**RE: Flatwoods Middle School – 100% Design Development  
Lillington, NC – Harnett County**

Preliminary construction documents (design development) received on 8-6-2024 relative to the above-named project has been reviewed for general compliance with the 2018 edition of the North Carolina State Building Code with the following comments. This review does not replace the plan review of the local Authority Having Jurisdiction (AHJ). This review is in addition to the plan review of the local AHJ. This plan review may contain comments related to Accessibility, Plumbing, Mechanical, Electrical, and Fire Codes.

1 PARTIAL SECOND FLOOR - AREA 600 EAST
A-116.1 SCALE: 1/8" = 1'-0"

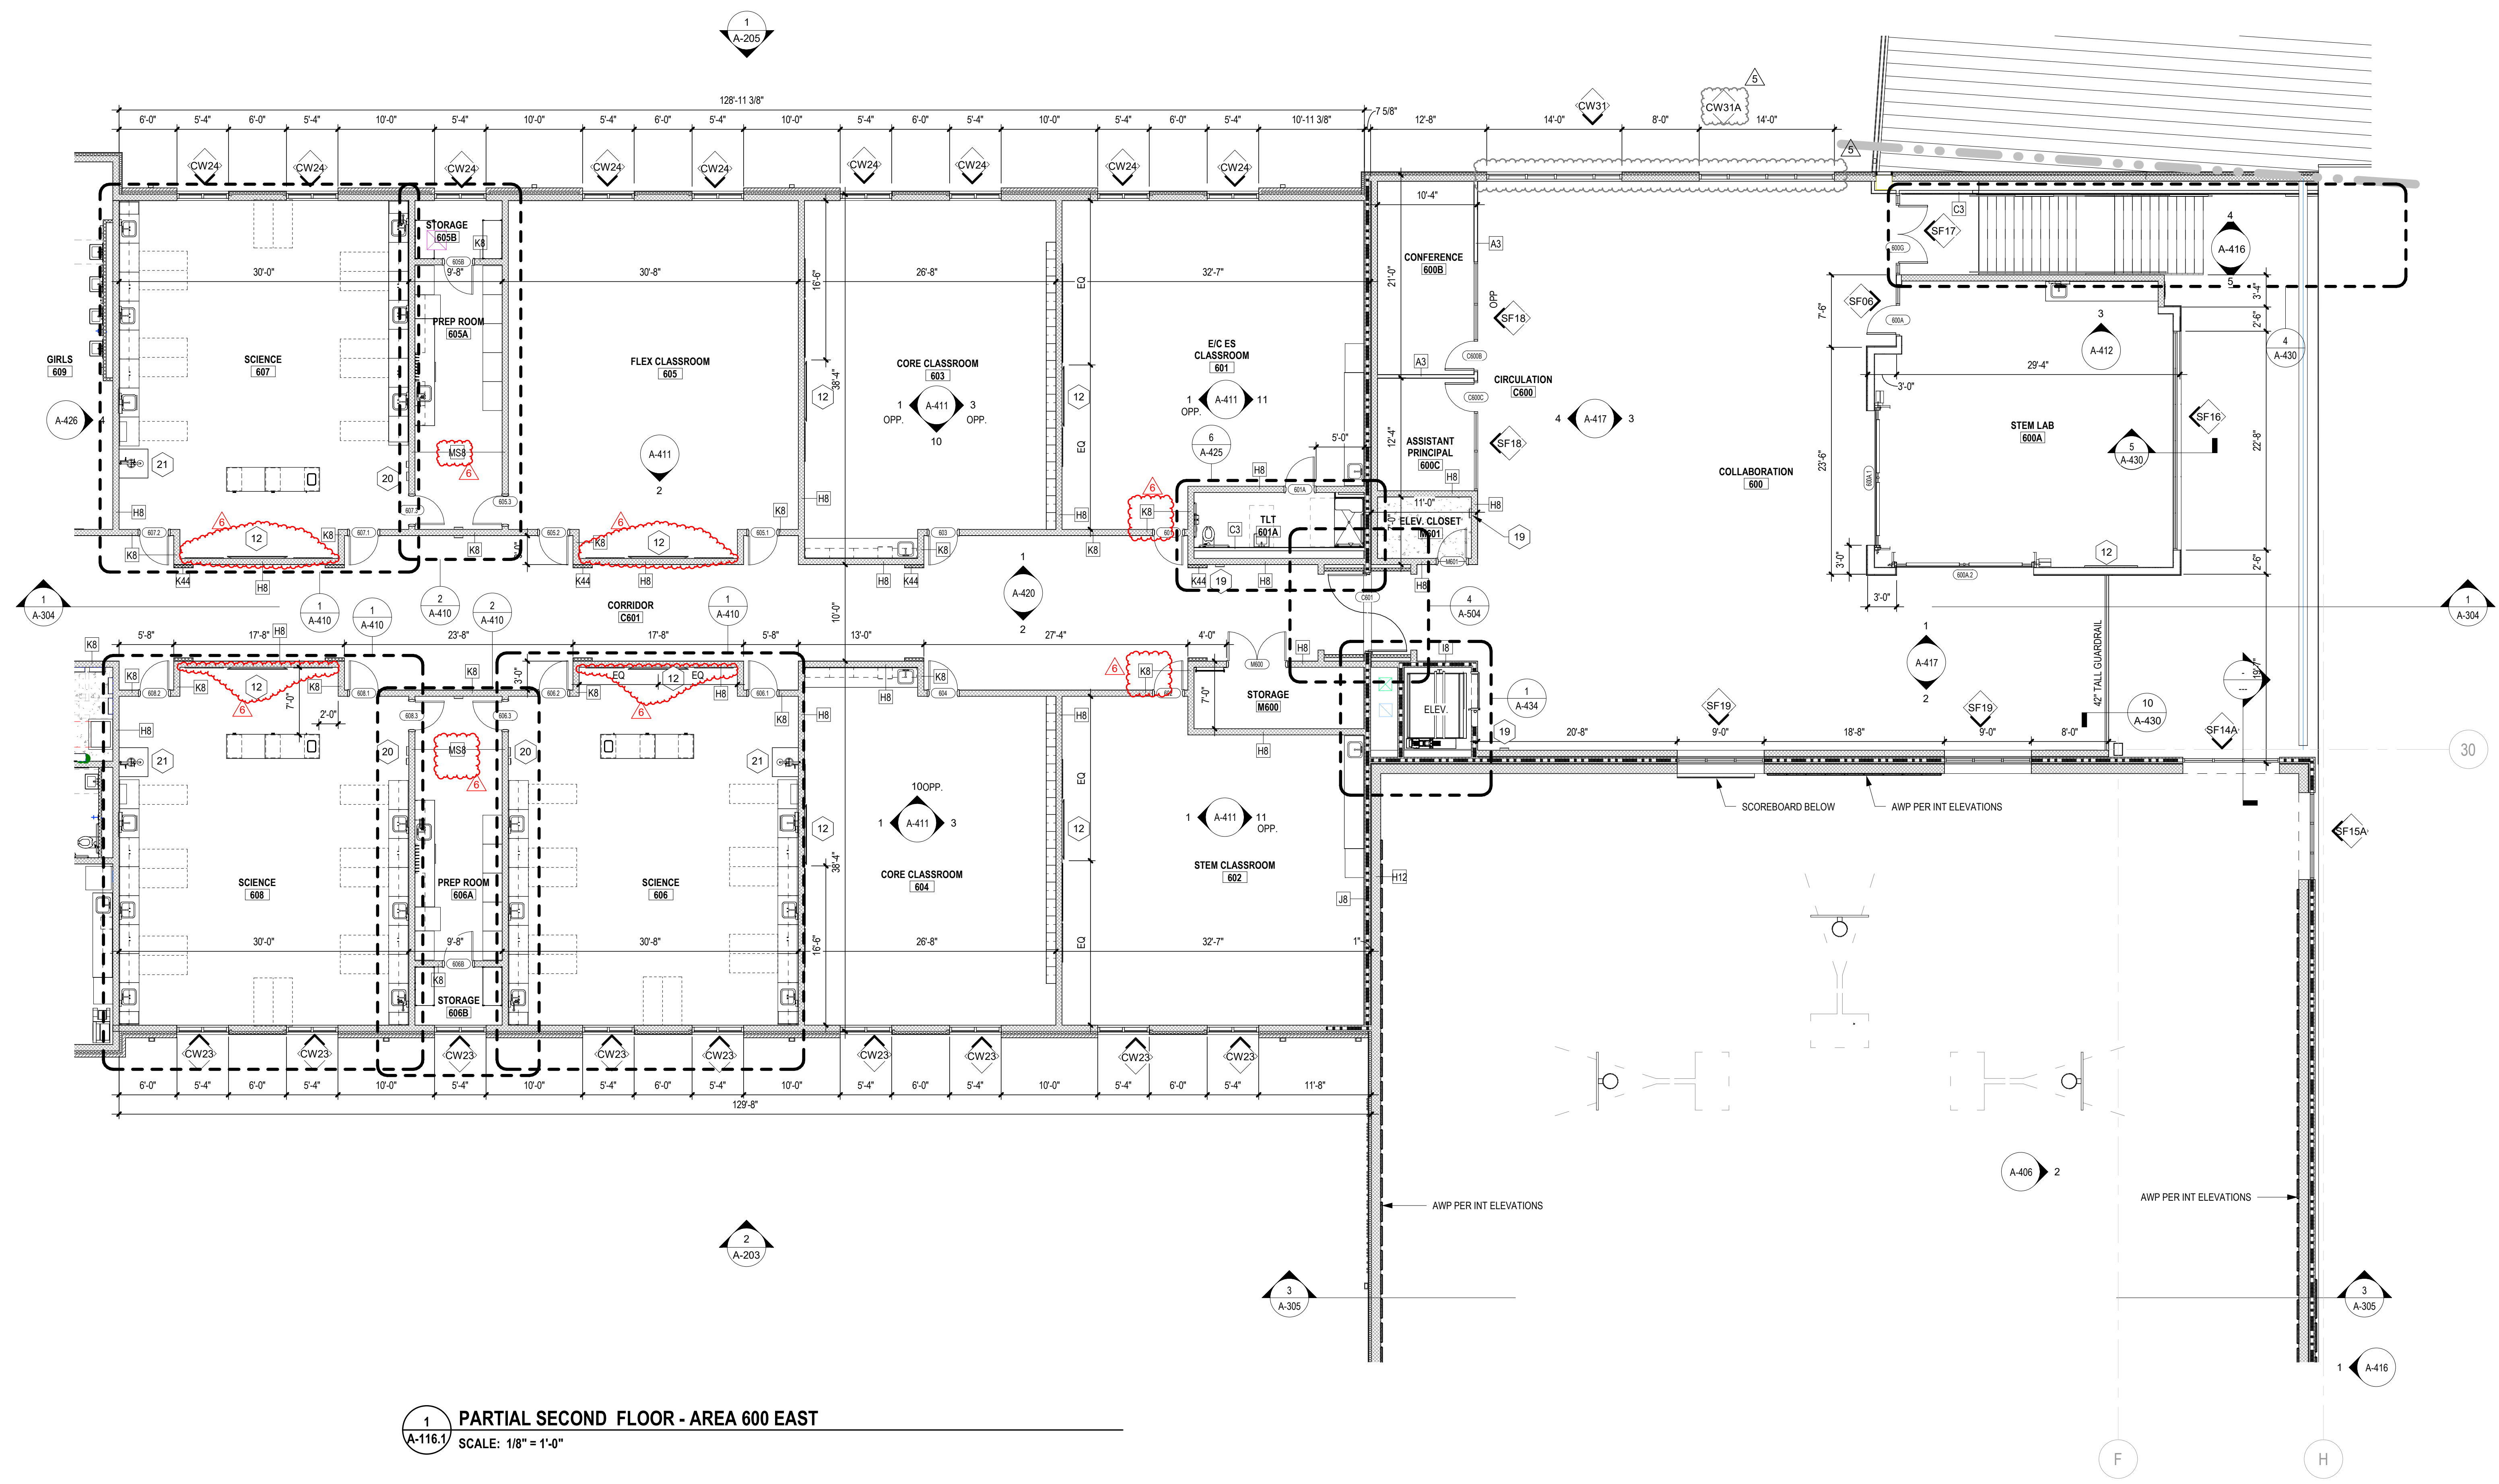
53. Provide mechanical exhaust/vent calculations for the smoke and heat vent system.
54. Pages M-114, M-115.1 and M-116.1, E-215.2 and E-801 – It appears that a few fire dampers are required in the rated wall separating the buildings.

ISSUE DATE: 01-09-25
PROJECT #: 02208.000
DRAWN BY: Author
CHECKED BY: Checker
© 2024 SFL+a Architects, PA
All Rights Reserved
FLOOR FINISH PLAN
- AREA 100

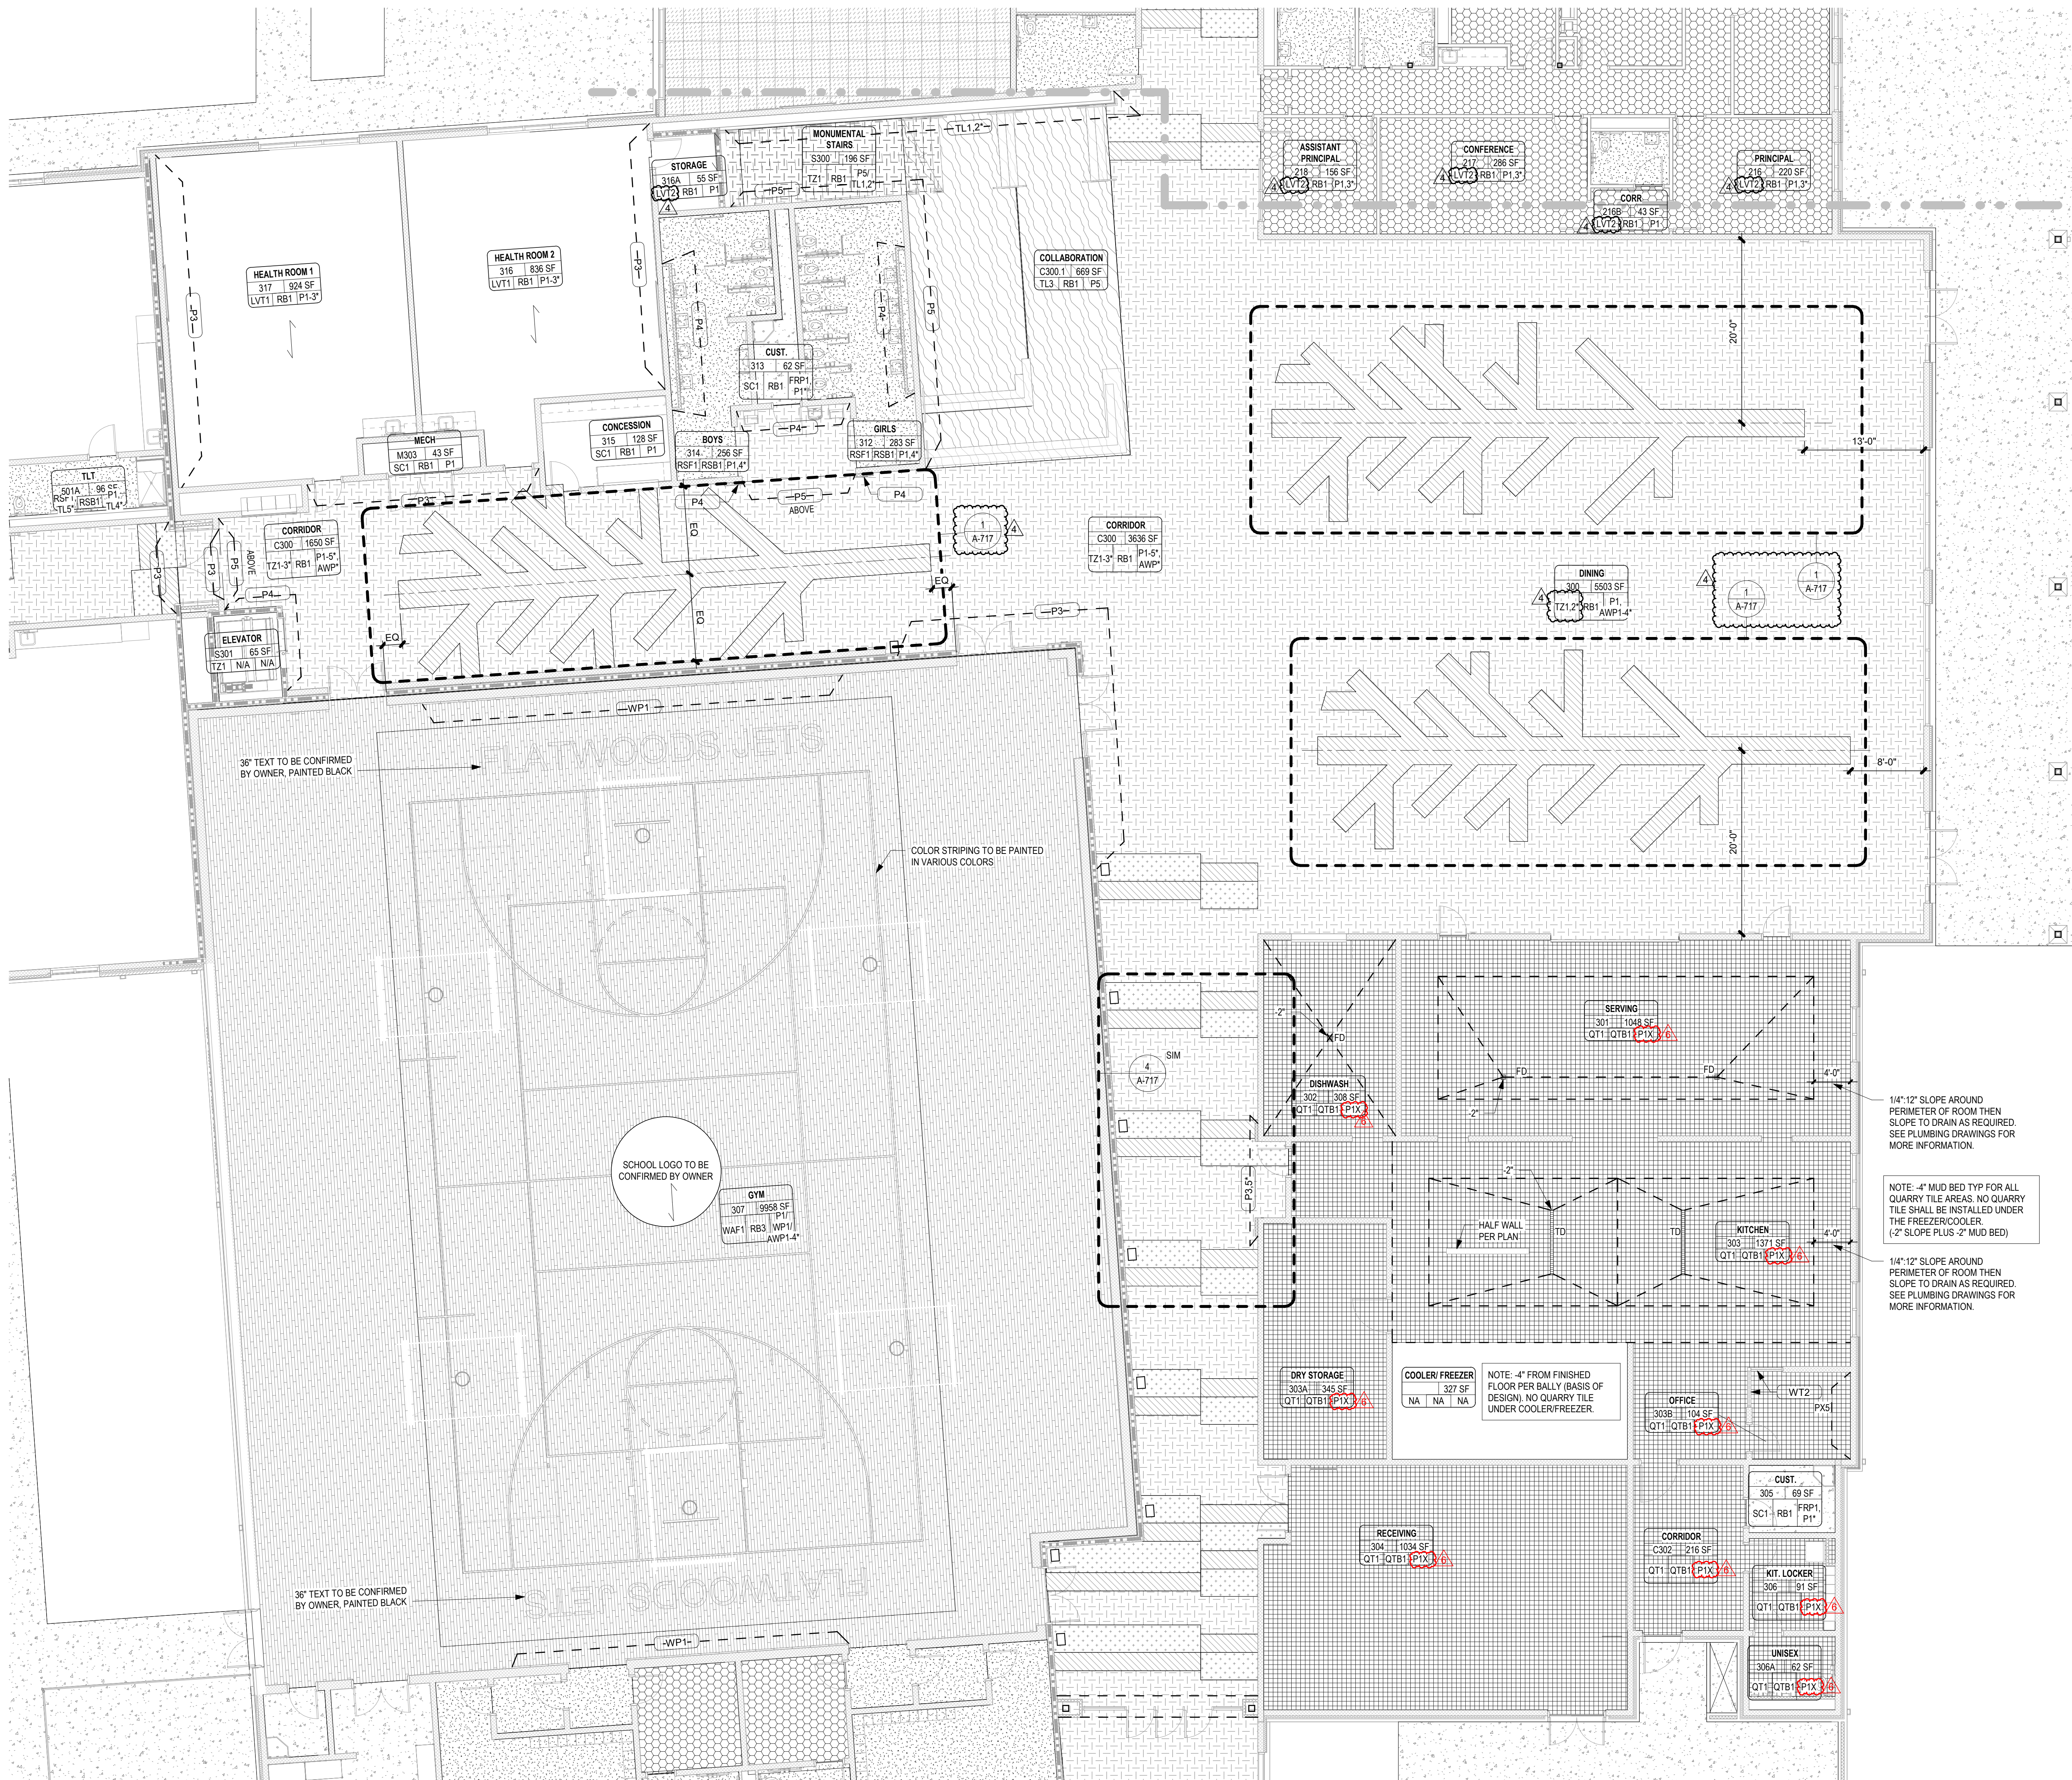
40. Specifications Manual Volume 1, section 08 71 00 – Door hardware to be completed, once determined.
41. Page A-701 - All new interior finishes to comply with Chapter 8 of the 2018 NC Building and Fire codes. Provide Class ratings on Finish schedules in the Notes column.

FA-112

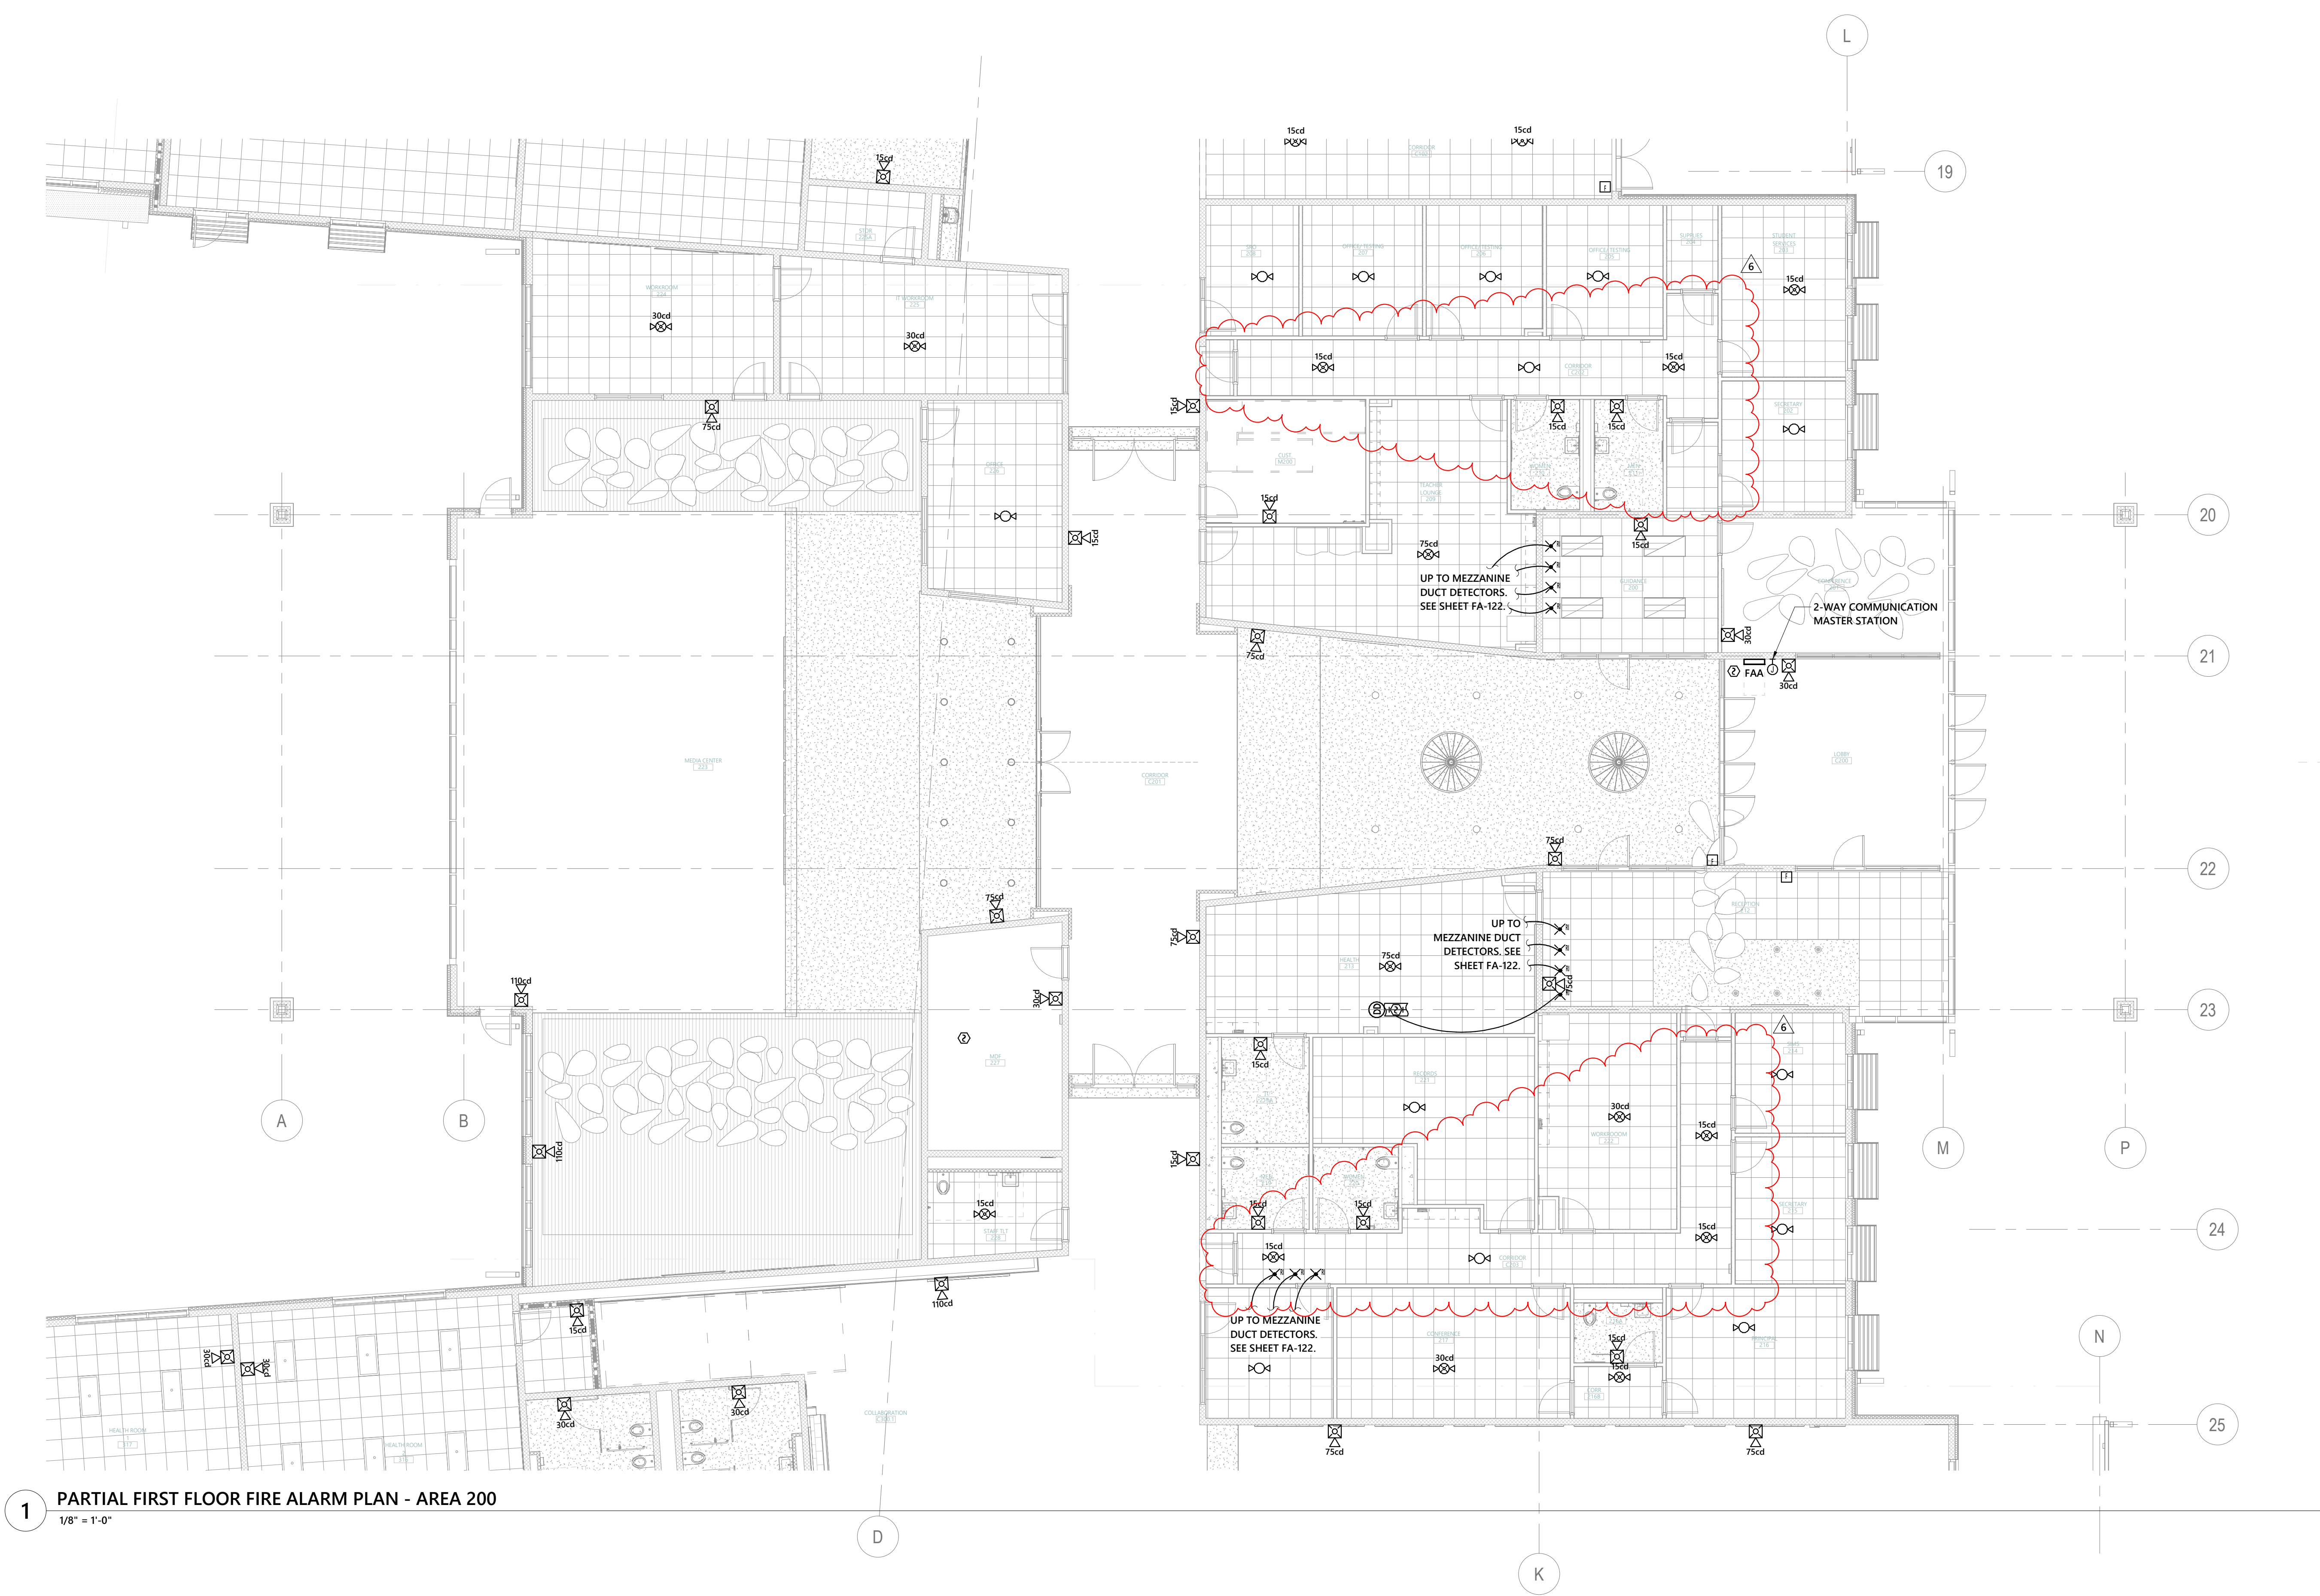
71. Pages FA-001 and G-002 – Fire Alarm Matrix and Fire Alarm Riser Diagram to include Carbon Monoxide, if gas fired appliances are present.
72. Page FA-112 – Lobby C200, Fire alarm remote annunciator will require protection at the panel, if it has control functions. 2018 NC Fire Code section 907.4.1
